# **AQUIND INTERCONNECTOR**

Applicant's Response to Deadline 2  
Submissions

Tables edited by Winchester City Council for its  
deadline 4 submission

Document Ref: 7.9.6

Plate 1 - Plots 3-12 and 3-13 as shown on Land Plan as at Application

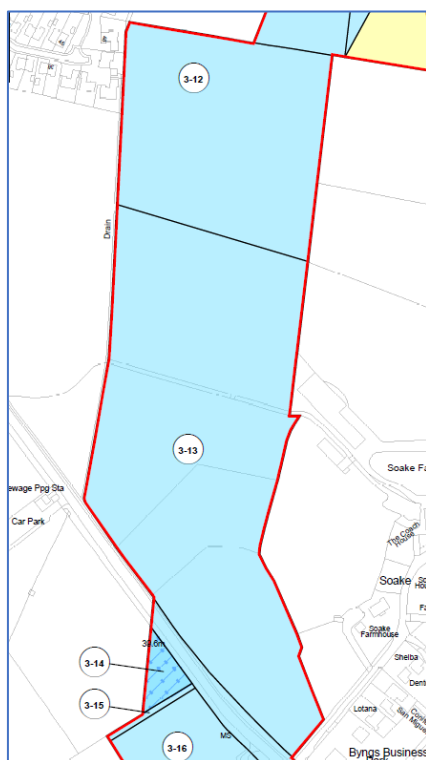
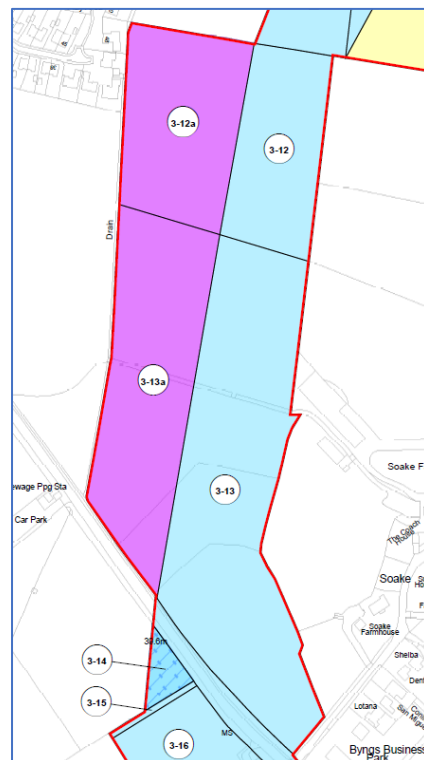
|                     | <p>The Council notes in 3.1.1.6 the adjustment to the land required for New Connection Work Rights at Soake Farm. However, the Council strongly objects to the retention of access rights as a haul route across this land as shown on plates 1 &amp; 2. A section of this haul route would cross part of the SINC designation.</p> <p>The Council welcomes the refinement to the Order Limit on Anmore Road as set out in 4.1 with the removal of the eastern cable route option, providing it is perfectly clear that the TPO tree and its root system are not impacted</p> | <p>The Applicant can confirm that any access rights required over Plots 3- 12a, 3-13a and 3-12 as shown on the updated Land Plans (REP1-011a) would not require a haul road as installation of the Onshore Onshore Cable Route in this area would be by horizontal directional drilling (HDD) rather than open trenching and the reference to a haul road in the Position Statement in relation to the refinement of the Order Limits (REP1-133) was in error. It is possible a short length of haul road may be required in Plot 3- 13, though this would be in relation to the HDD compound which could be located in the southern part of Plot 3-13 (immediately north of Hambledon Road).</p> <p>While the Applicant has retained rights over land at Denmead Meadows, Soake Farm Meadows SINC is avoided through HDD works as outlined in the ES addendum (REP1-139).</p> | <p>The Council notes the correction.</p> <p>However, it would question if the intention to protect the SINC by HDD is not undermined by the ambiguous wording that follows and refers to the intention to form .....a short length of haul road in plot 3-13 .... . This plot is more than just the intended drill launch field.</p> <p>The council still has concerns over the installation of the cable at Denmead Meadows and they are being discussed separately. Hopefully, those discussion will come to a conclusion shortly. In the event they are successful, it will be the Councils position that any activity associated with the two drilling compounds (north &amp; south) are confined to the two distinct areas allocated as compounds and there is no vehicular or pedestrian access link between them other than simple survey walkover rights to ensure for example there is no breach of drilling fluid onto the surface.</p> |
